CHERWELL DISTRICT COUNCIL CORRESPONDENCE

From: [REDACTED]@Cherwell-DC.gov.uk>
Sent: 16 August 2021 08:51
To: [REDACTED]
Cc: [REDACTED]
Subject: RE: Jct10 M40 Landscape and Visual matters [21/0708/PREAPP]

Figure 13.1: Viewpoint location plan

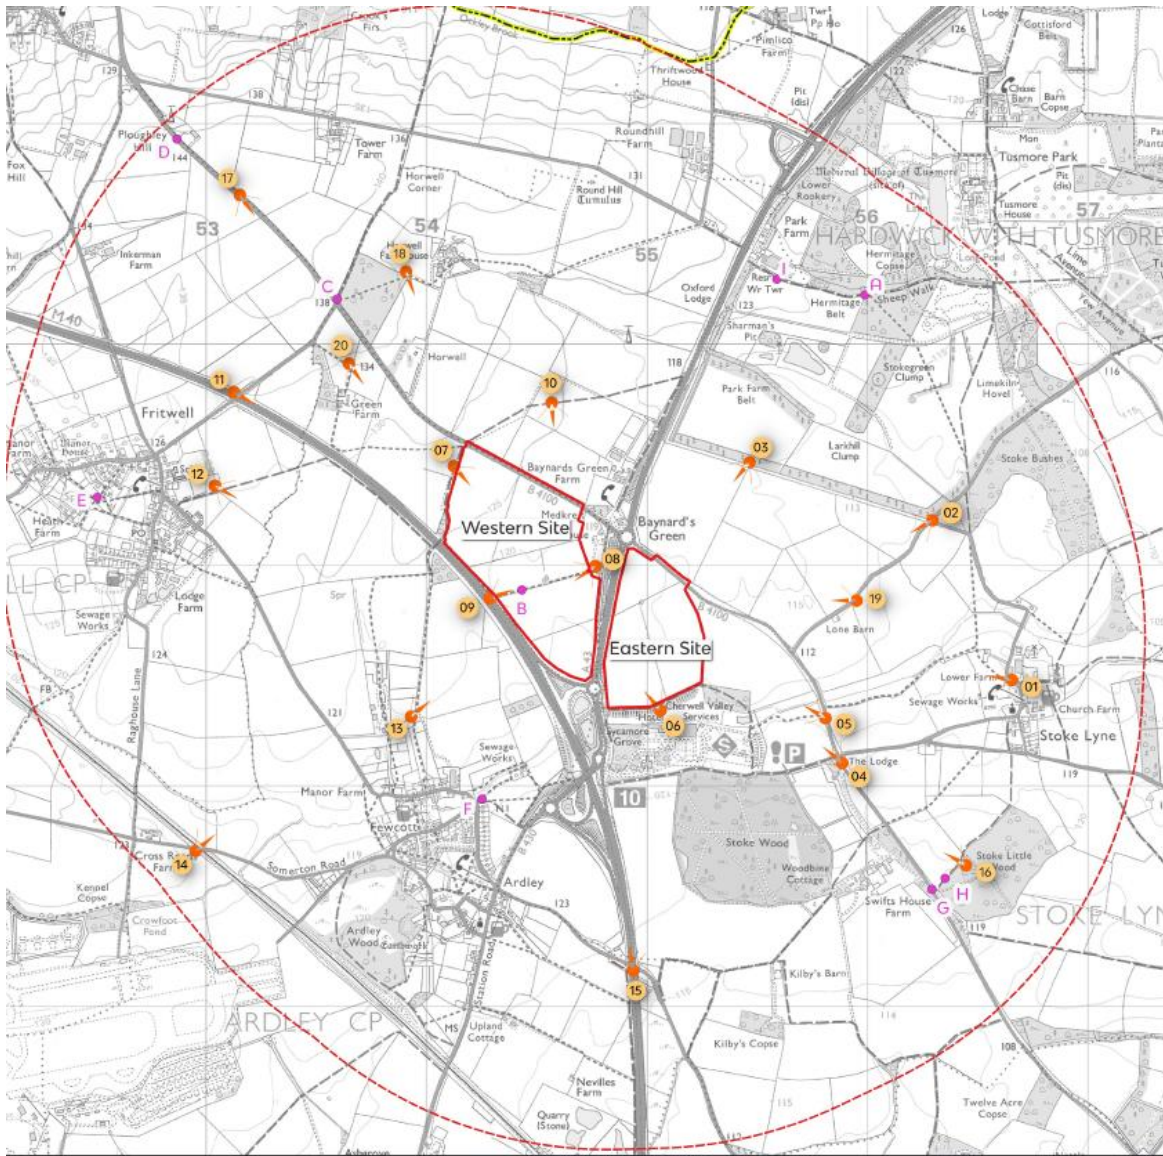
are you able to include residential receptors?

The 'scoped out' viewpoints do not have to be photographically recorded, however I would prefer to see a narrative for each as they are in 'logical' locations on the plan (if intervening topography obscures the site/scale/massing then this should be mentioned). I would like to see a photo-record for A because this is a visual receptor on/near an important heritage receptor.

The rest of the viewpoints are a good representation of the visual experience. I personally would include a two view (or more) sequence of the PRow approach to the site, where the receptor may have an enhanced experience of the site's scale/massing, which would directly influence weighting and subsequently the design of the landscape masterplan.

The inclusion of a brief narrative describing the rationale for scoping out Photoviewpoints A – E will form part of the LVIA chapter.

A Photoviewpoint was initially considered from location A but was discounted during the site work phase of the LVIA. However, Photoviewpoints 2 & 3 are adjacent to the parkland and have views over the wider landscape whereas those from A do not, being enclosed by successive hedgerows and areas of woodland. An assessment from

Photoviewpoints 2 & 3 are illustrative of views encountered from the southern edge of the parkland and, it is felt, represent a 'worse case' scenario for receptors.

With respect to residential receptors, aside from its location on a PRoW part of the reasoning for the selection of Viewpoint 8 was to capture, from a publicly accessible location, potential views from the residential properties situated adjacent to the Western Site. I trust this selection is satisfactory.
